Five Estuaries Offshore Wind Farm

Appendix I3 to the Natural England Deadline 3 Submission
Natural England's comments on Seascape Landscape Visual Assessment Wirelines
and Updated Viewpoints [PD4-010 to PD4-012] and [REP2-031 to REP2-038]

Planning Inspectorate Reference EN010115

12 November 2024

Wireline drawing

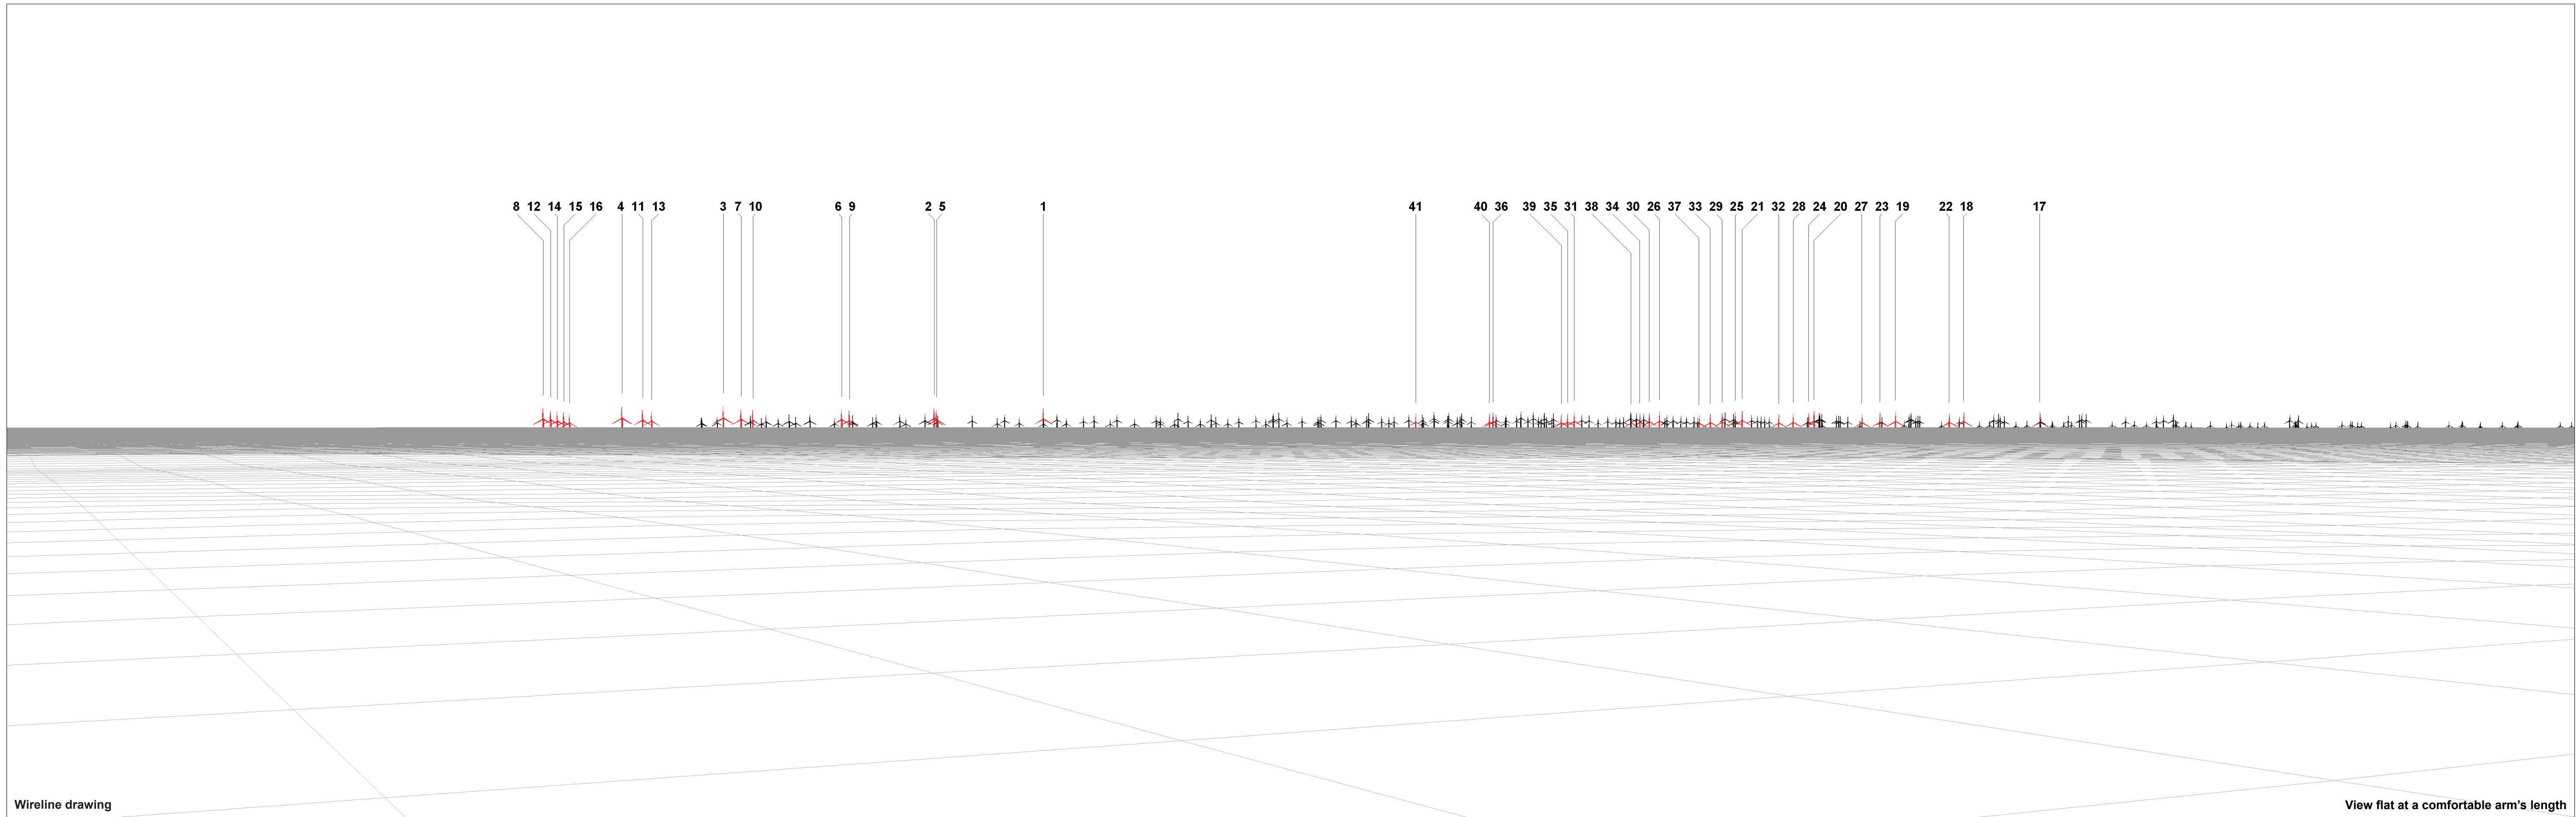
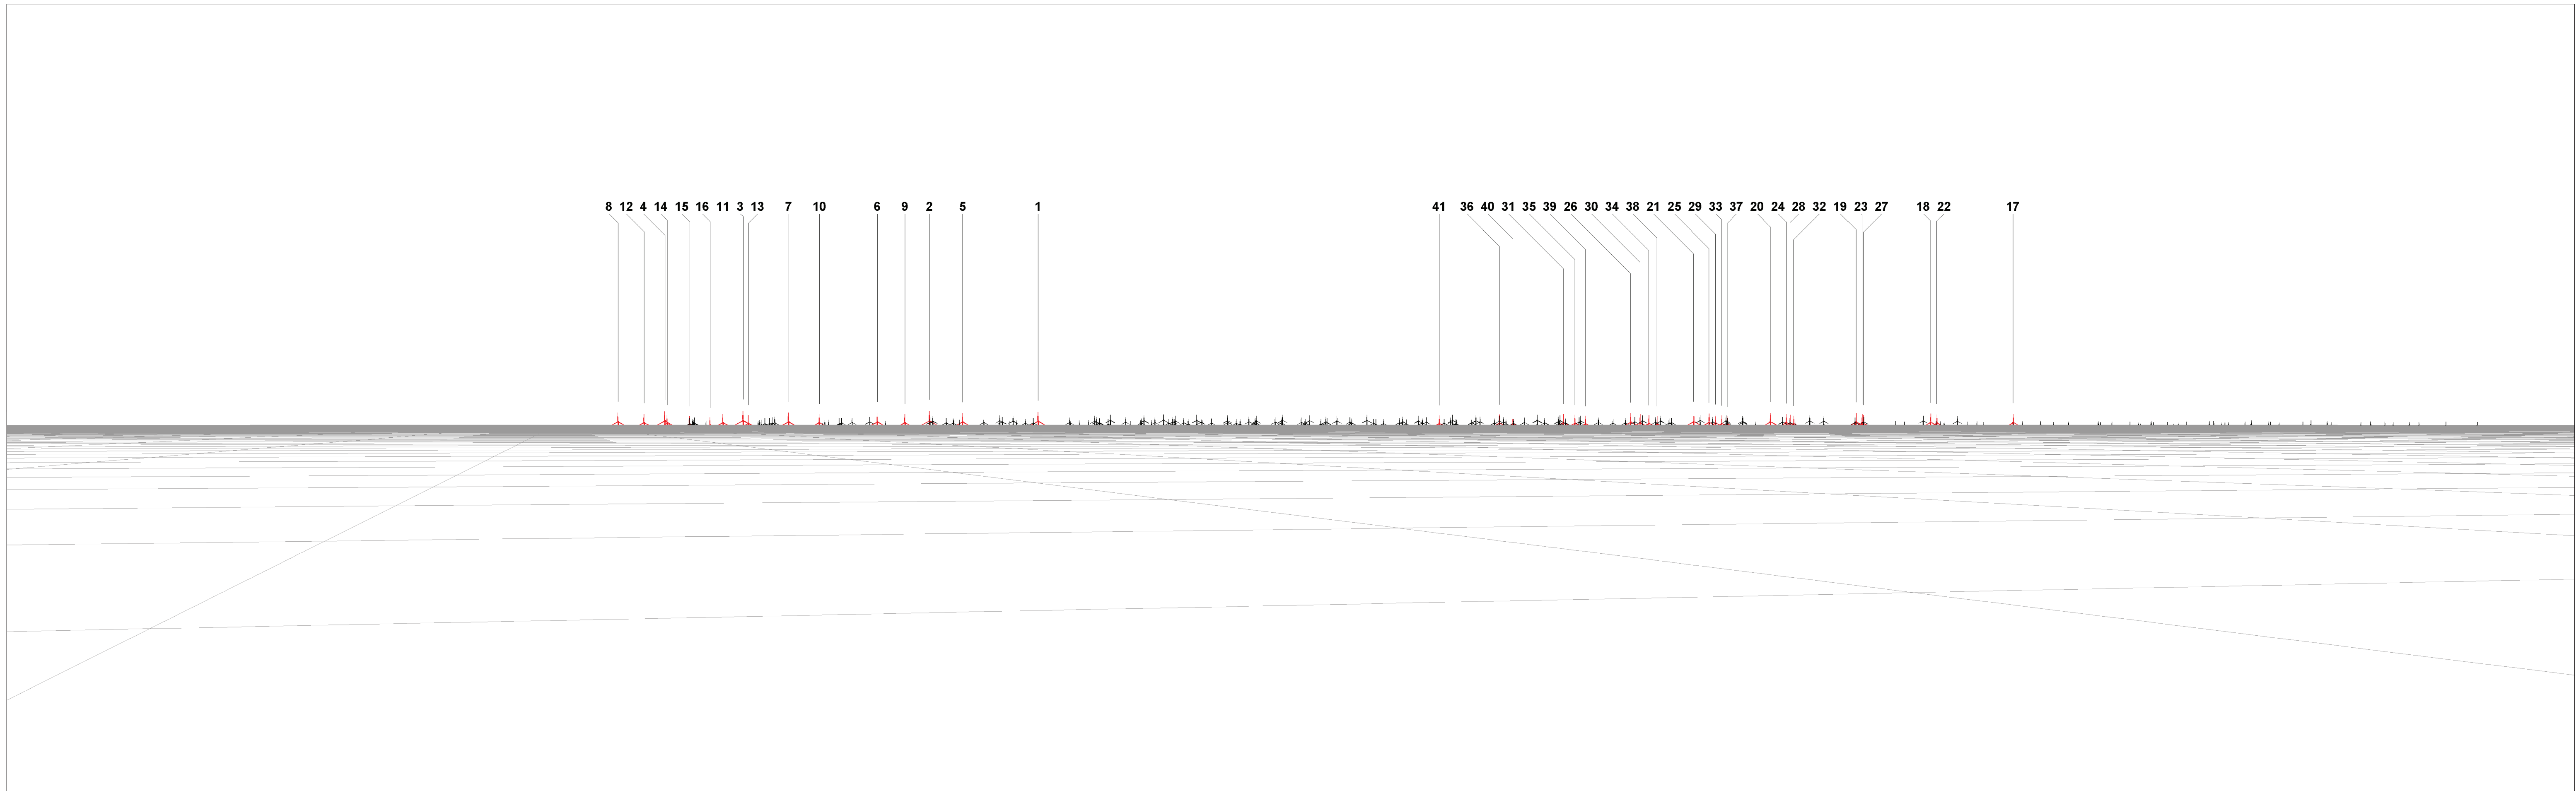
Document reviewed: [REP2-031 to REP2-038] 10.21.1 to 10.21.8 Updated SLVIA Viewpoints 1-6, 9 and 10 (Figures 10.26 to 10.31, 10.34 and 10.35) – 370m Tip Height			
NE Ref	Section	Key Concern and/or Update	Natural England's Advice to Resolve Issue
1	General Comment	The viewpoints chosen for updated wireframes for 370m LAT option are the key viewpoints within the SCHAONB. The 29m reduction in the height to turbine blade tip has not changed Natural England's advice in relation to the significance of seascape and visual effects associated with the statutory purposes of the SCHAONB, SHC, and their seascape settings.	Natural England's advice remains unchanged.
